Your Ref BR/311/18/PL

Our Ref: NW/ARU/16/03B

RE Land to the East of University of Chichester , Upper Bognor Road , Bognor Regis PO21 1HR

Thank you for your correspondence of 12th December 2018 advising me of the 'Erection of 176 bedroom student accommodation building with associated hard & soft landscaping. This application may affect the setting of listed buildings, may affect the character & appearance of the Upper Bognor Road, Mead Lane Conservation Area & is a Departure from the Development Plan' application for which you seek advice from a crime prevention viewpoint.

DRAWING TITLE
Proposed Ground Floor Plan

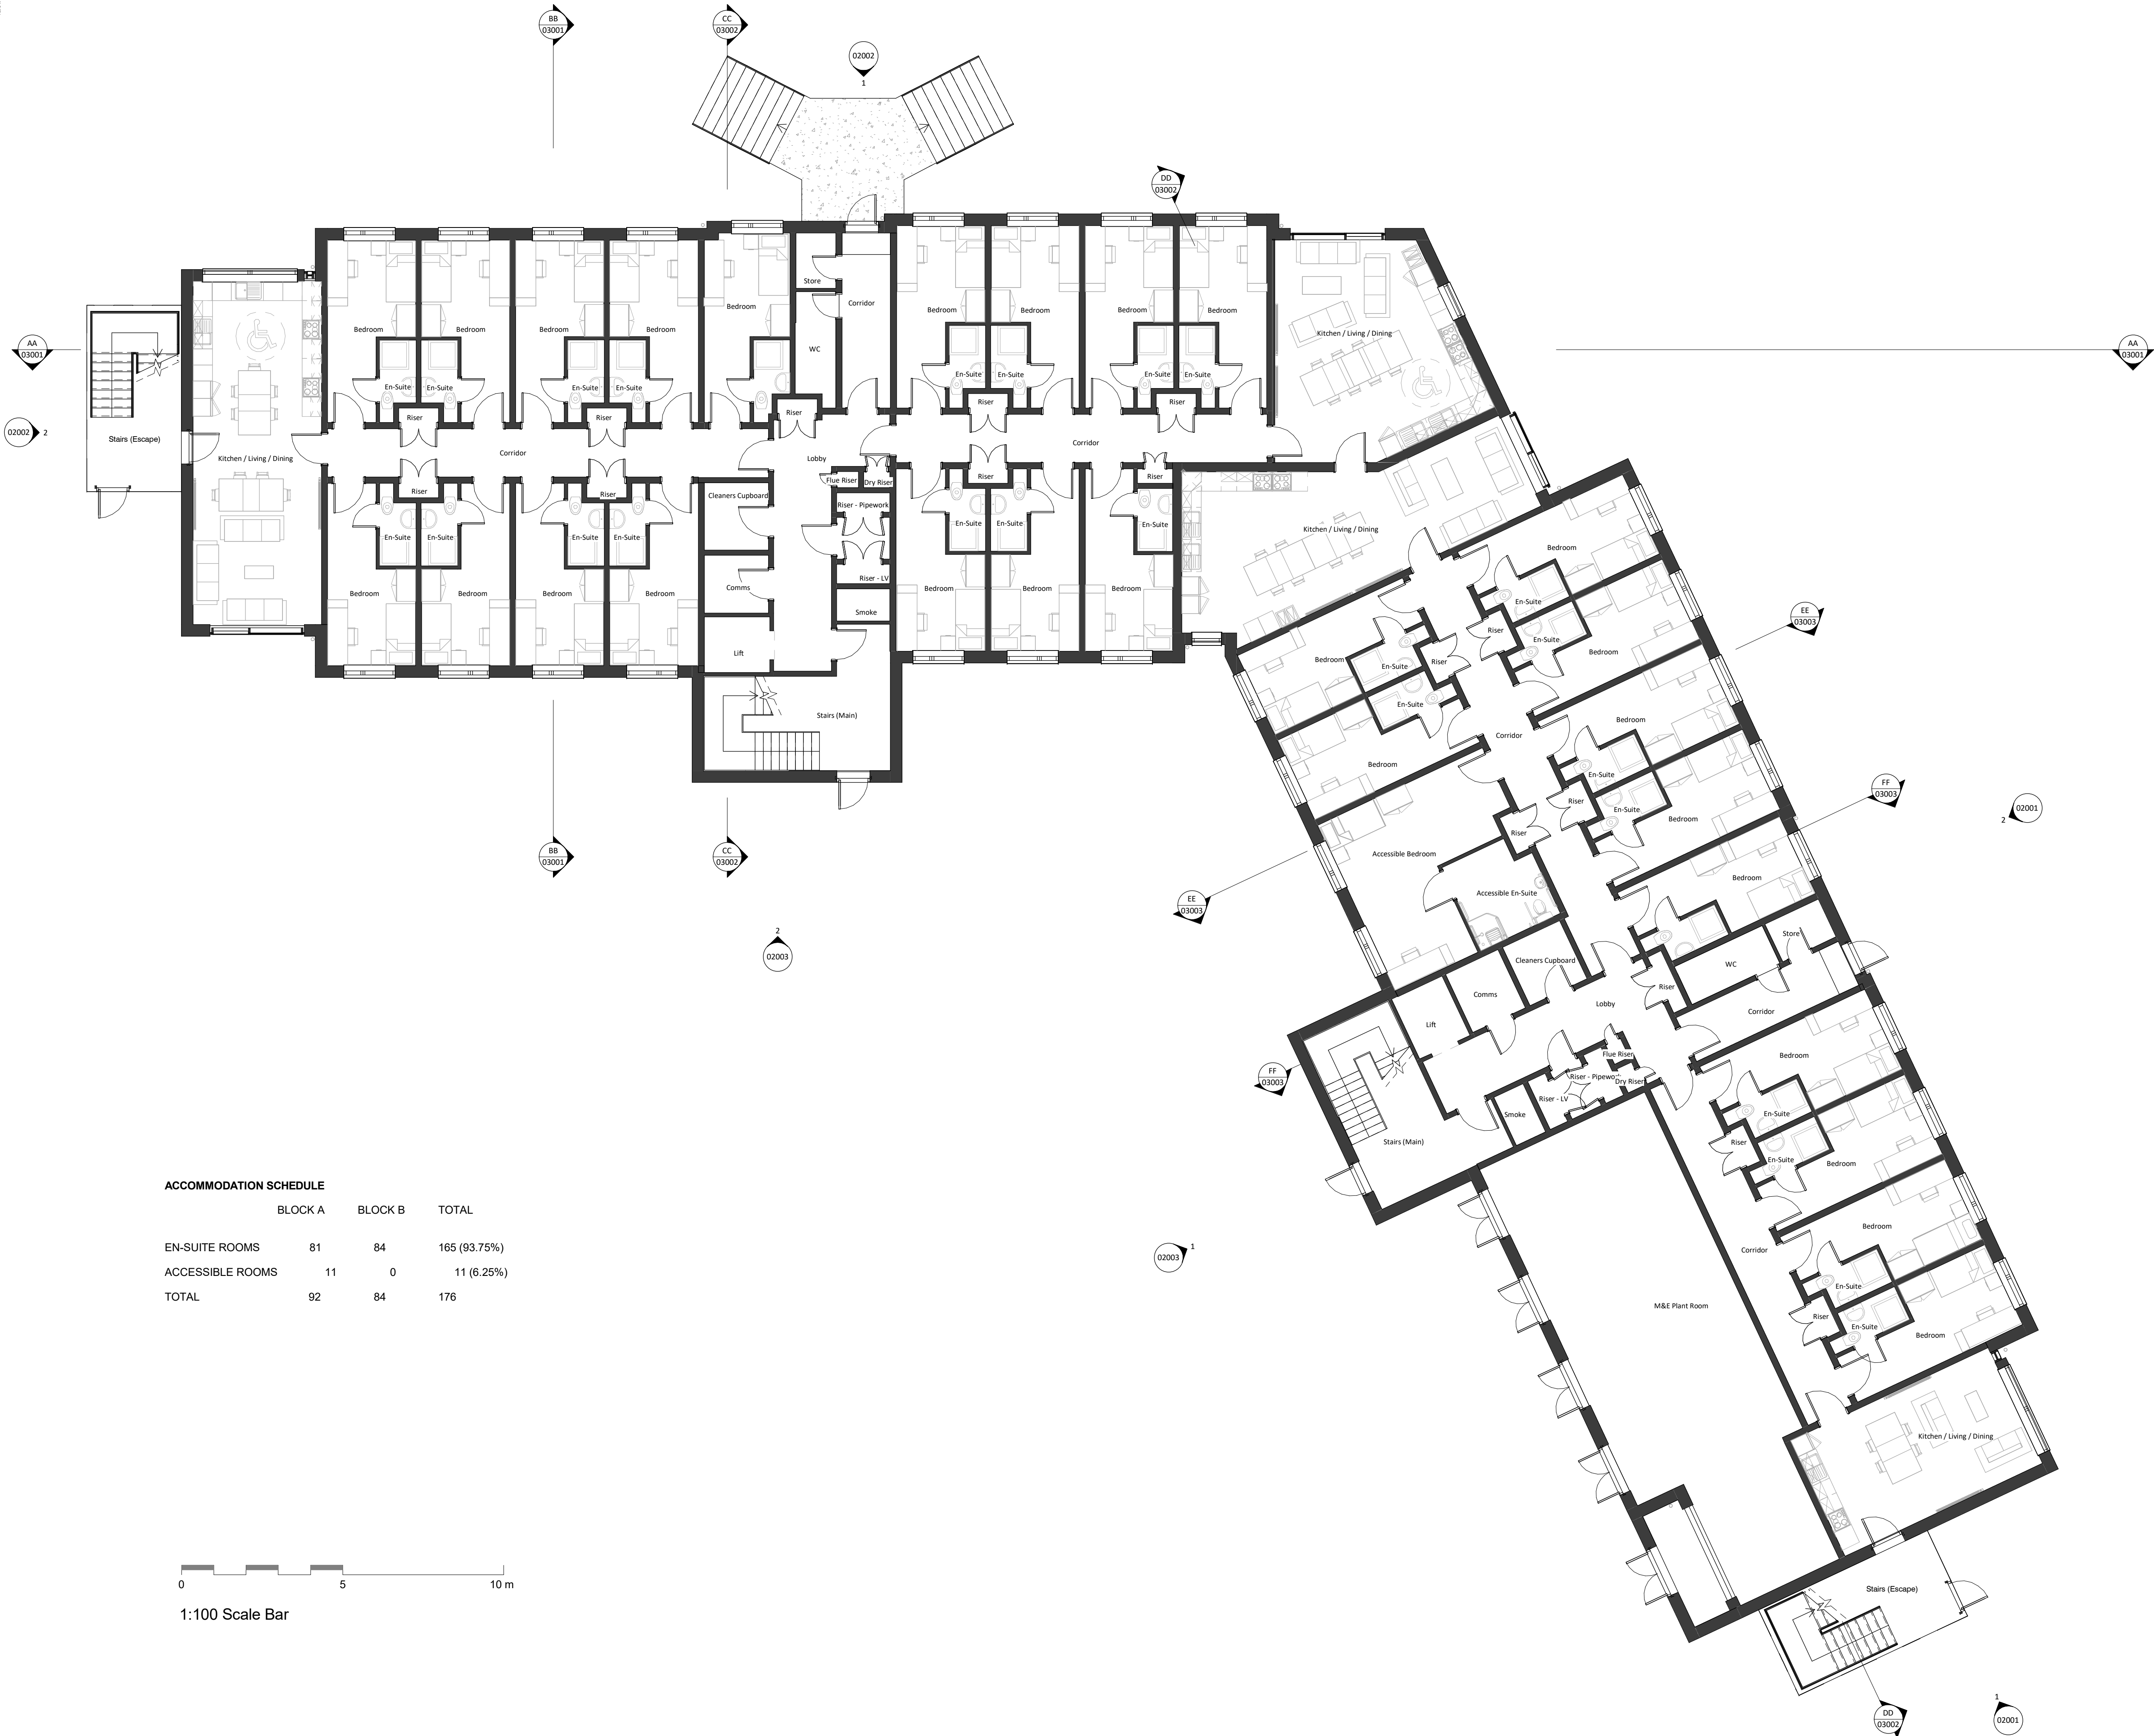
The student accommodation entrance doors will be required to deal with heavy use over a long period and provide security. Therefore I would recommend that all ground floor communal entrance doors to the student accommodation meet the requirements of LPS1175 Issue 7 SR:2 or STS 202 Issue 2 with controlled access and have remote release of the primary entrance door set.

I note that the plant room of Block A has four double outward hinged doors and no internal access to the living accommodation. If the plant room is to be vented via external louvered doors, the area around the lock must be internally protected to prevent access though the louvres and the doors should be a certificated steel door with access control and movement activated switched lighting within the room.

I recommend the external double door sets are certificated and fitted with spring loaded automatic shoot bolts to the unlocked doors to ensure they close first and should be fitted with an automatic door closers. The doors must have controlled access and an internal means of releasing the door to prevent persons from becoming unintentionally locked in.
